Your Ref: OWPC22886
Our Ref: FG/29/19/PL 15-03-2019
Please ask for:
Mrs A Gardner

13th May 2019

Erection of 1 No. 2 bed dwelling
South Point 1 Beehive Lane Ferring

Proposed Site Plan, Location Plan,
and Context Plan

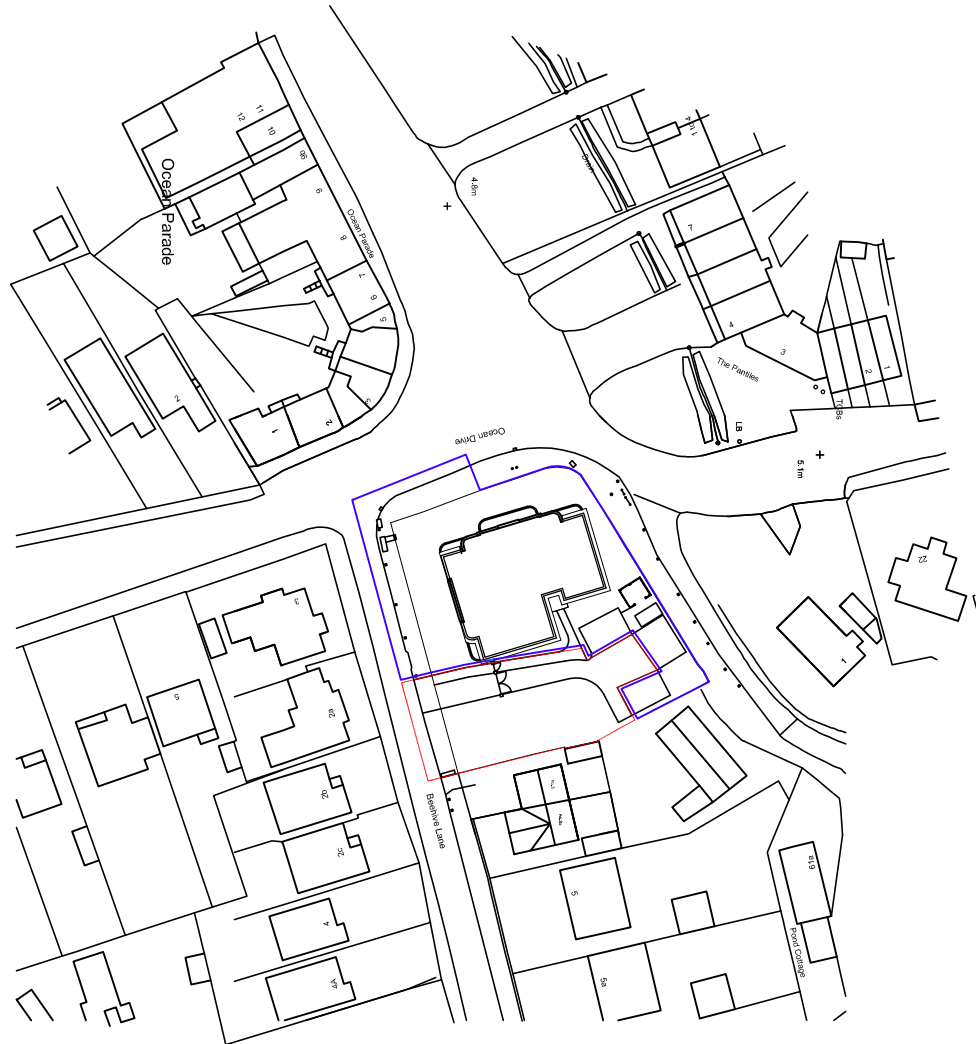
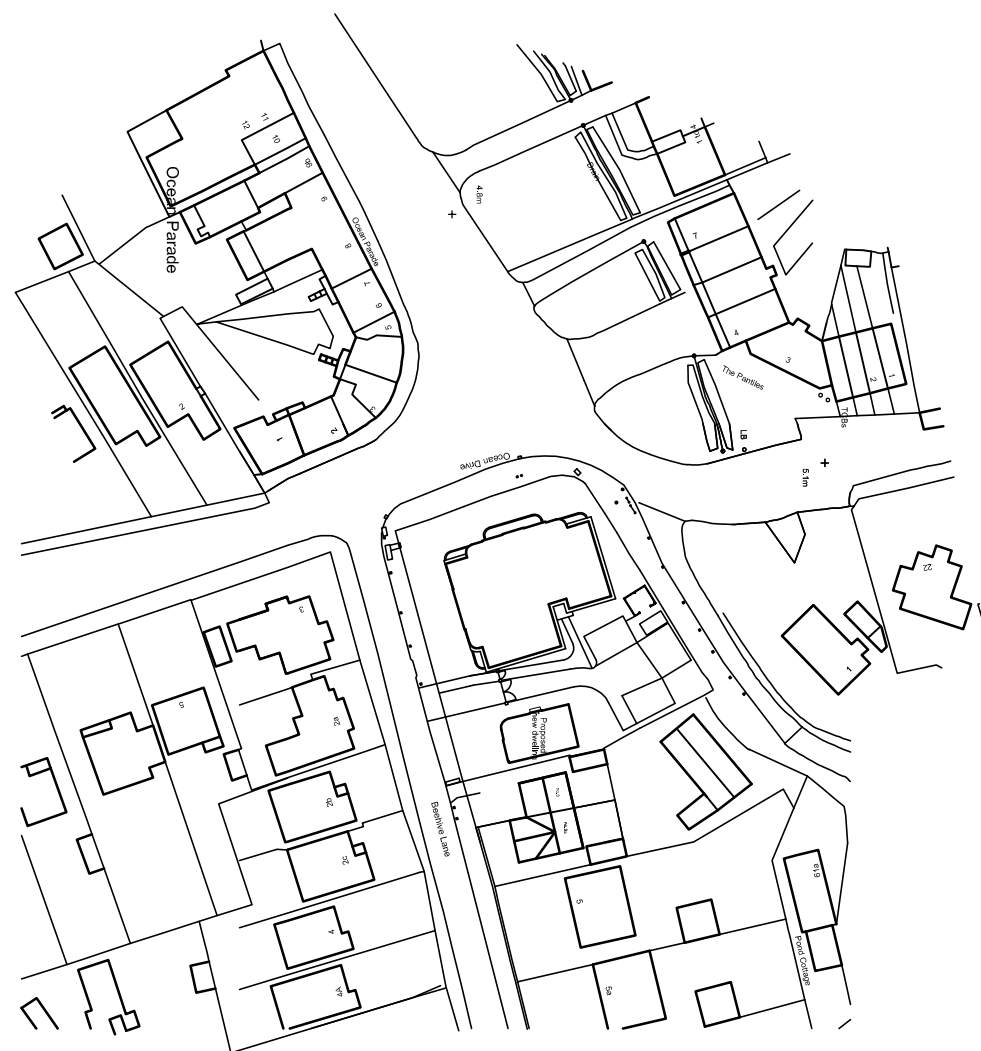
1. The larger structure will impinge significantly on the neighbouring property at 3 Beehive Lane, cutting out light to the front door and lounge window. We understand from reading previous correspondence online that the Developer advised the owner of 3 Beehive Lane that this land would not be developed but would remain as a buffer between the flats and her property.

2. Despite the conclusions of the Inspector, parking will be a problem. As a bus route, Beehive Lane is not suitable for on road parking as it is a narrow road with no pavements, and on street parking will make it difficult for buses, refuse vehicles, delivery vehicles etc to get past safely and without potential harm to pedestrians and cyclists. One visitor's parking space is clearly insufficient for 9 dwellings.

3. In their refusal of Application no FG/194/17/PL, Arun DC considered that the proposals for a one bedroom bungalow were an overdevelopment of the site. Plans for a larger two bedroom bungalow must therefore be even more of an overdevelopment and must therefore be refused on similar grounds.
